DECISION DELEGATED TO DEVELOPMENT MANAGER

Application No: H16-1018-19 **Applicant:** Mr T Smith
Proposal: Two-storey rear extension
Location: 50 St Pauls Road Spalding
Terminal Date: 12th December 2019

Proposed Elevations

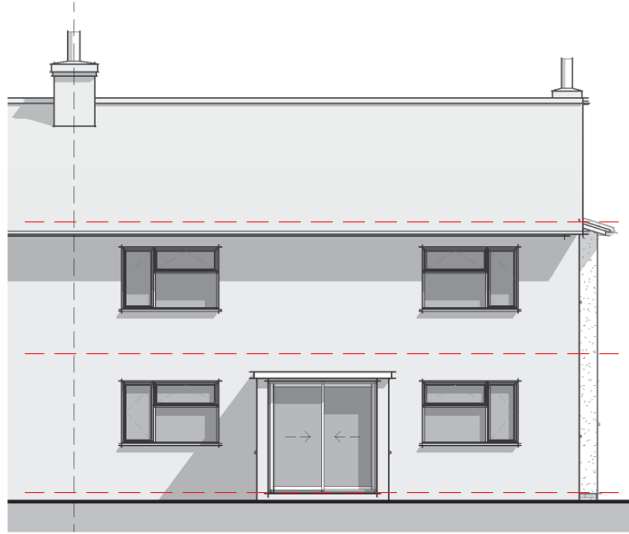
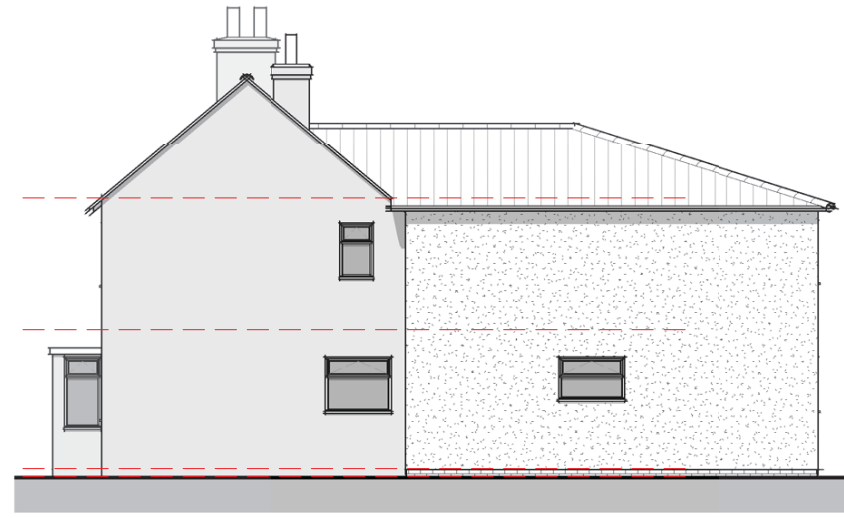
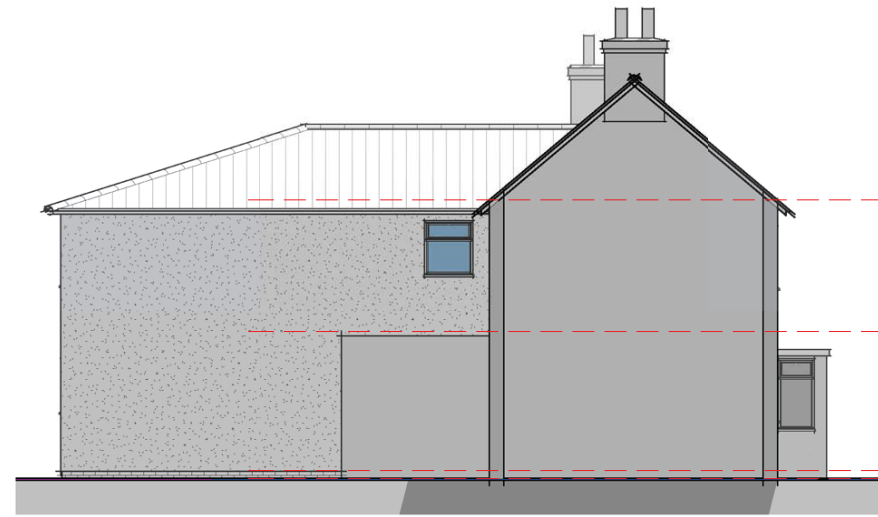
The amended plans have seen the agent adopt a stepped approach to the development with a flat roof for bedroom 4 which allows sunlight to enter the upstairs window of without breaching the 45 degree calculation for "right to light" up to the middle of the adjacent window at 52 St Pauls Road. The footprint of the extension slightly exceeds the 45 degree calculation but it not considered to be at a level of detriment material enough to justify a recommendation for refusal.

There is not uniform development style to the built environment in the area. The location of the property and extension is such that being to the rear of the building and being a sizeable distance from all but the adjacent property, there is not considered to be an overlooking impact, and render to be used will only be to the rear of the property, not visible from the site frontage.
